# CITY OF PORTLAND BUILDING PERMIT

16 LONGWOOD DR

**PERMIT ID:** 2013-00896

has permission to **12' x 20' storage shed build**

FLOOR AND BASE PLAN

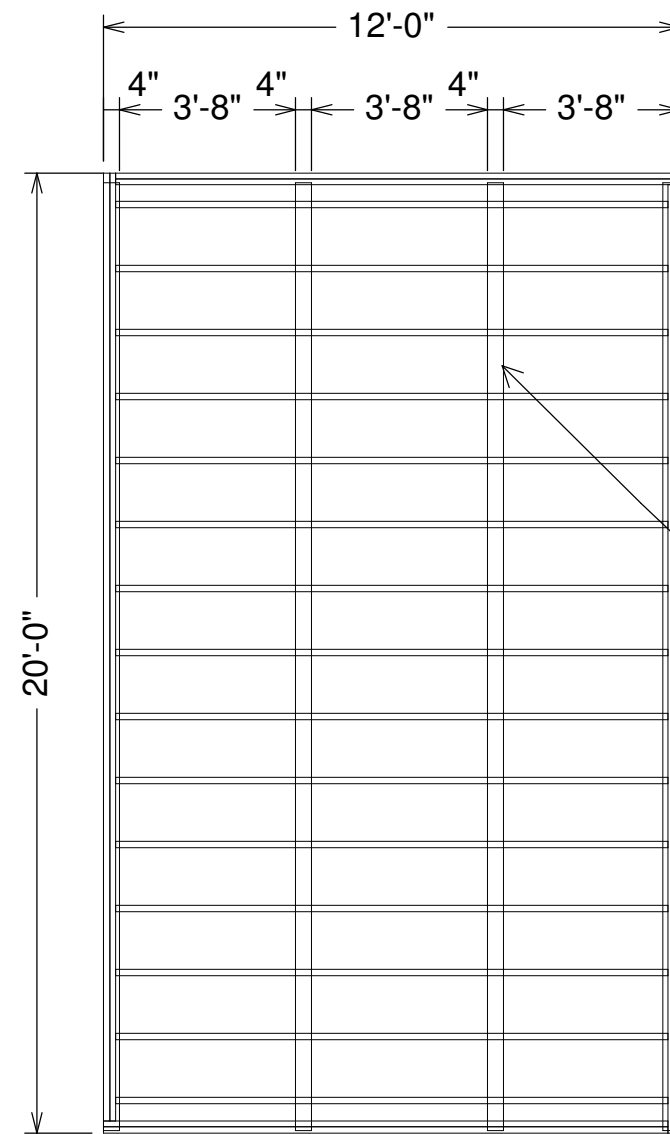
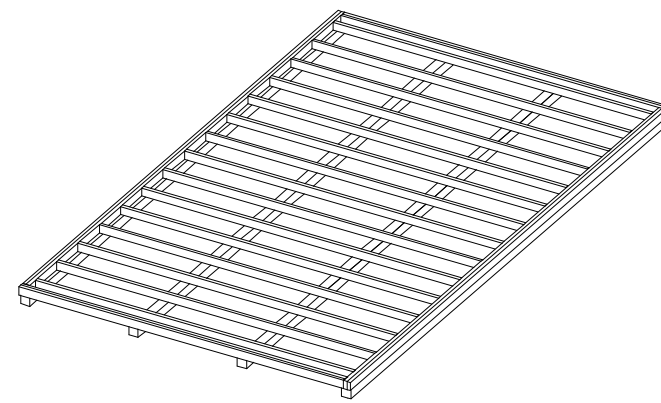
1) As discussed during the review process, the property must be clearly identified prior to pouring concrete or placement of the shed and compliance with the required setbacks must be established. Due to the proximity of the setbacks of the proposed shed, it may be required to be located by a surveyor. 2) This permit is being approved on the basis of plans submitted. Any deviations shall require a separate approval before starting that work. 3) This property shall remain a single family dwelling. Any change of use shall require a separate permit application for review and approval.				
<b>Dept:</b> Building <b>Status:</b> Approved w/Conditions <b>Reviewer:</b> Jon Rioux <b>Approval Date:</b> 05/21/2013 <b>Note:</b> <span style="float: right;"><b>Ok to Issue:</b> <input checked="" type="checkbox"/></span>
